Planning Application Ref: CM/37/18/OUT

Location: Mistletoe Farm, Horsemere Green Lane, Climping BN17 5QZ

Description of works: Outline application with some matters reserved for the redevelopment of site with 2 no. 4-bed detached bungalows & associated works (resubmission following CM/10/18/OUT). This application is a Departure from the Development Plan.

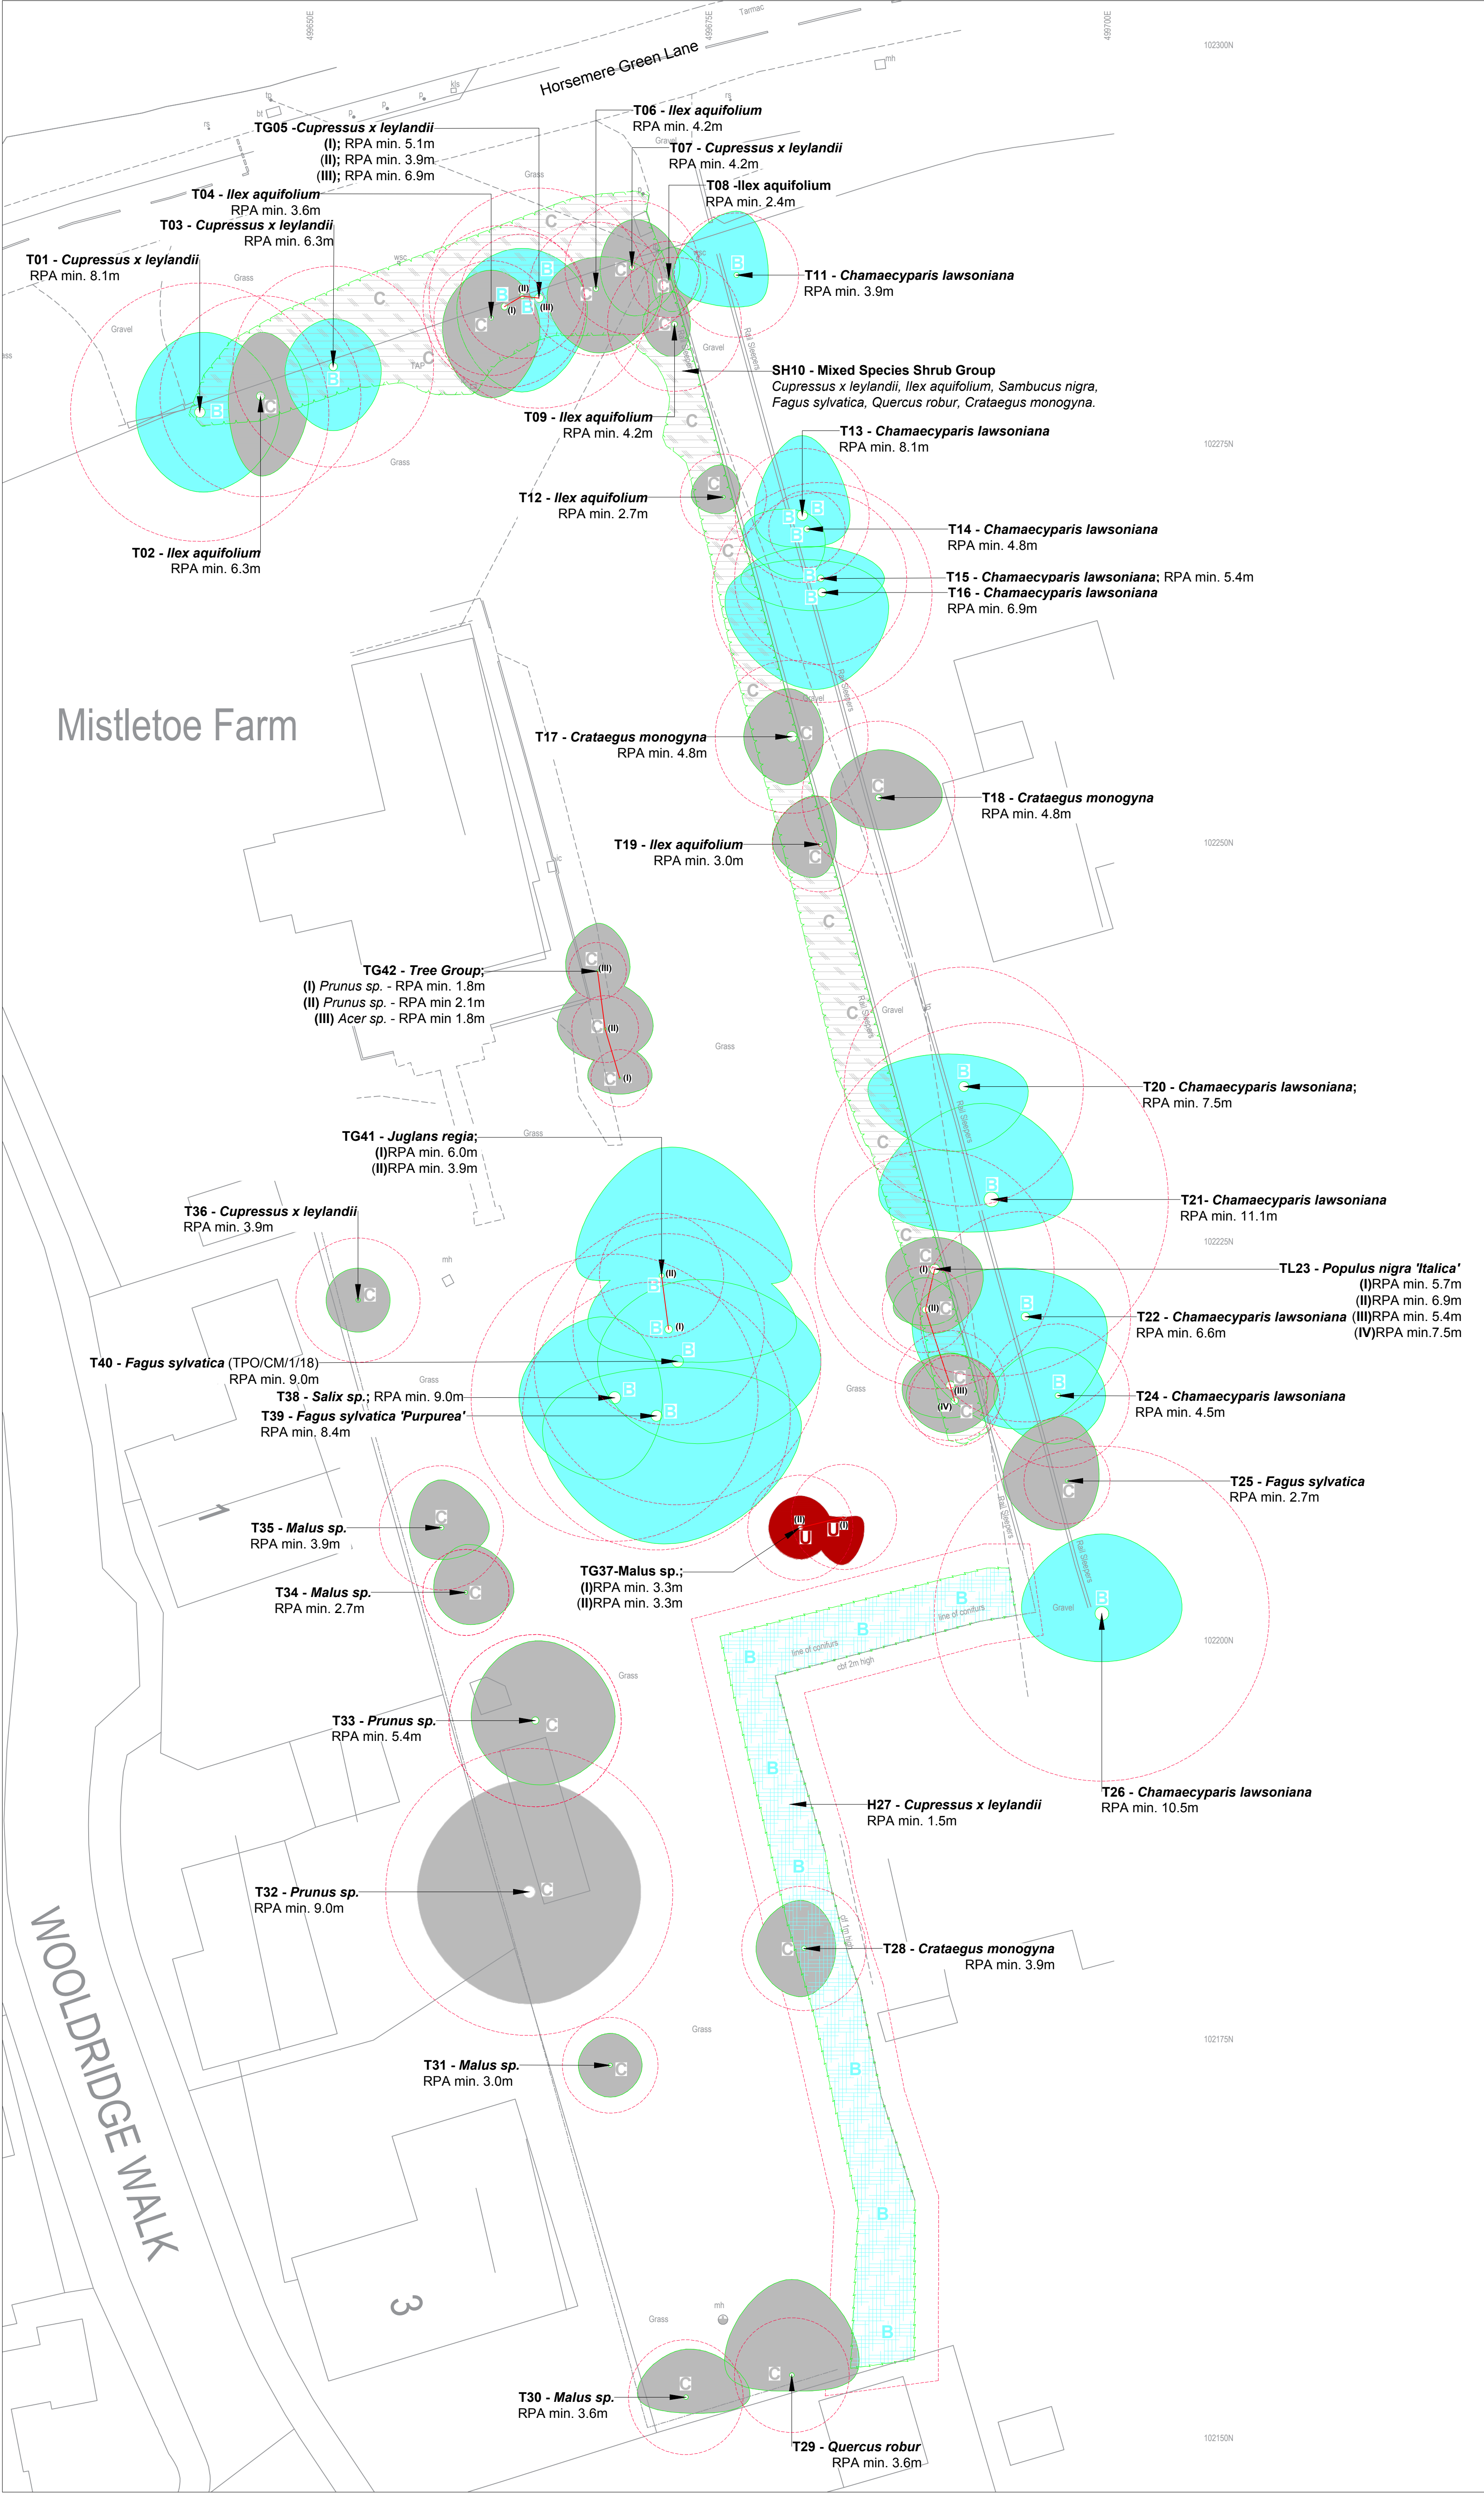
- The existing tree schedule needs to reflect all and any changes to the original proposal and those must be shown on an updated tree retention and protection plan. The Arboricultural Impact Assessment and Arboricultural Method Statement must also reflect those changes where required, so that there can be no ambiguity and those documents can then form part of any subsequent condition.

- The project arboriculturists Lizard Landscape Design Ltd have submitted a revised AIA, AMS and Tree Retention and Protection Plan (TRPP) to reflect the required changes. The AIA makes early reference to the initial (superseded) TRPP which is unfortunate as the rest of the document is supportable. It is important for all to note that the latest TRPP as described in conditions below is the ultimate and defining plan that instructs the process on-site.

- Before the site is occupied or any machinery is introduced to the site or demolition work or construction work or alterations to existing ground levels takes place a **PRE-COMMENCEMENT Site Meeting** is to take place between the Arun DC Tree Officer and the Arboricultural Expert representing the site owners – at this meeting all protective fencing will be inspected along with any ground protection measures – they will be assessed to verify that they are 'Fit for Purpose' as required under British Standard 5837:2012 and have been erected and positioned exactly as shown on the **Tree Retention and Protection Plan ref: LLD1394-ARB-DWG-002, Rev02.**
